Maritime &
Coastguard
Agency

Application by Equinor for an Order Granting Development Consent for the Sheringham and Dudgeon Extension Projects.

Examination Timetable – Deadline 1 – Written Representation

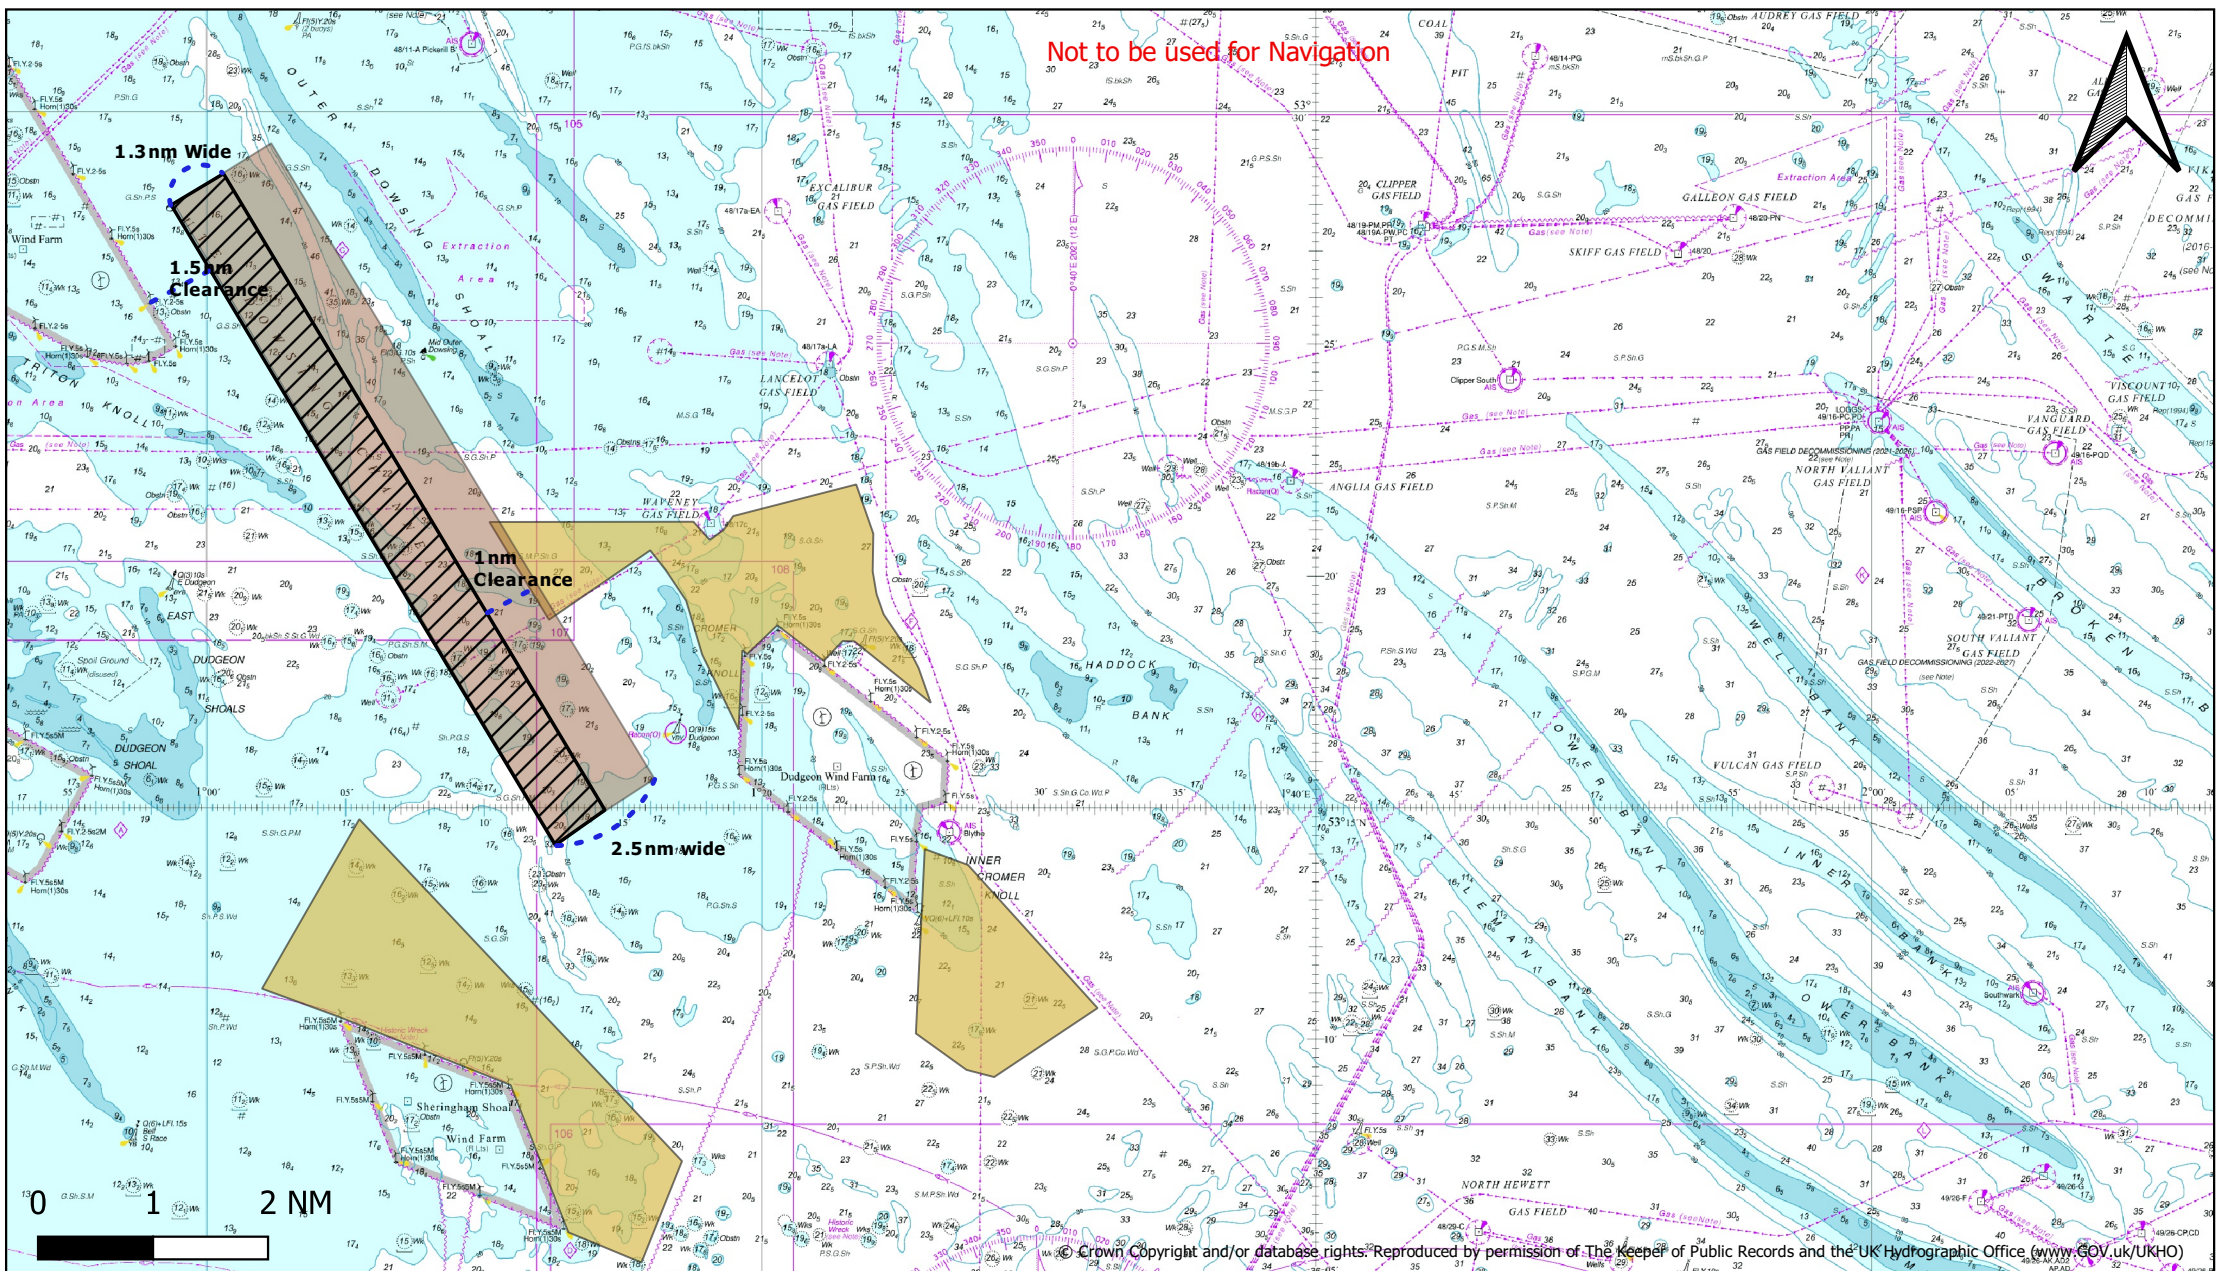
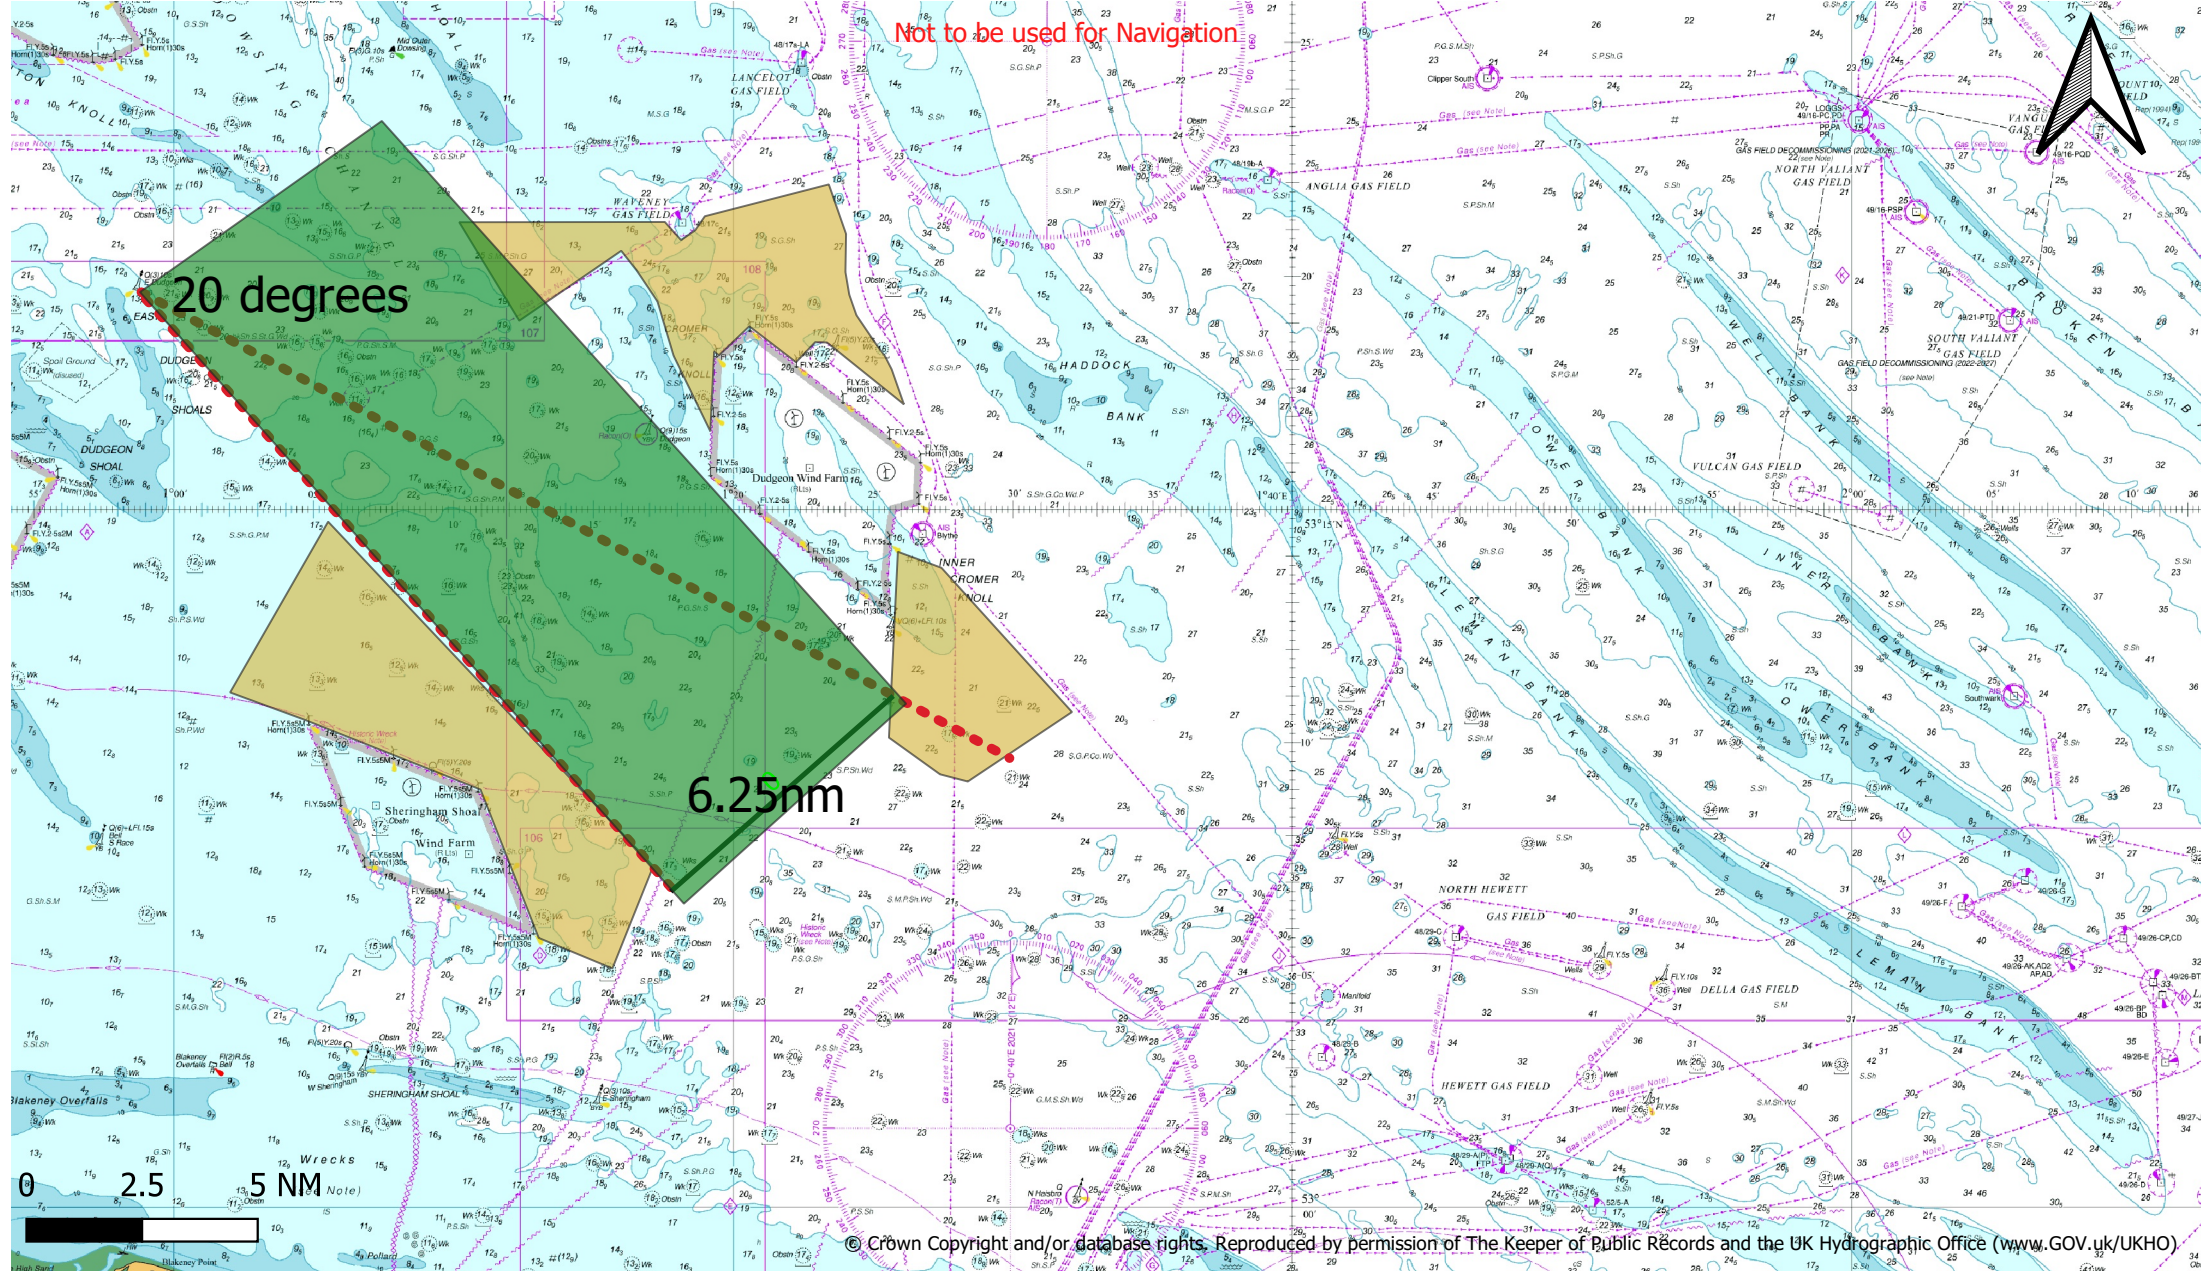
The irregular shape of the Dudgeon Extension will result in further loss of sea room to the west of the northern array. Vessels transiting east of Triton Knoll offshore wind farm (in the Outer Dowsing Channel) are constricted by the Dowsing Shoals and shallow water east of Triton Knoll into a route 2.5NM wide (90th percentile). The western boundary of the northern Dudgeon Extension array encroaches into this route and reduces the width to 2NM, however when a safety buffer is applied, it is likely that 90% of vessels will be constricted into a navigable space of 1NM wide. This does not appear to have been considered for assessing the potential frequency of encounter and collision likelihood scores within the hazard log.

In Fig 18.1 of the NRA the 20% corridor guidance from MGN 654 has been used to show the minimum width required for the 11.2NM long corridor between the extensions should be at least 4.1NM. The boundaries at the narrowest point are 5.6NM apart, however it is noted that shallow banks marked by the East Dudgeon buoy potentially extend the corridor length a further 6.5NM to the northwest since there is no safe sea room to the west of a line between the East Dudgeon buoy and the northern corner of the Sheringham Shoal Extension boundary. As such, it is arguable the length of the corridor would be 17.2NM and the required width as per the guidance in MGN 654 should be at least 6.25NM.

MCA therefore suggests the red line boundary is revised to reduce these risks.
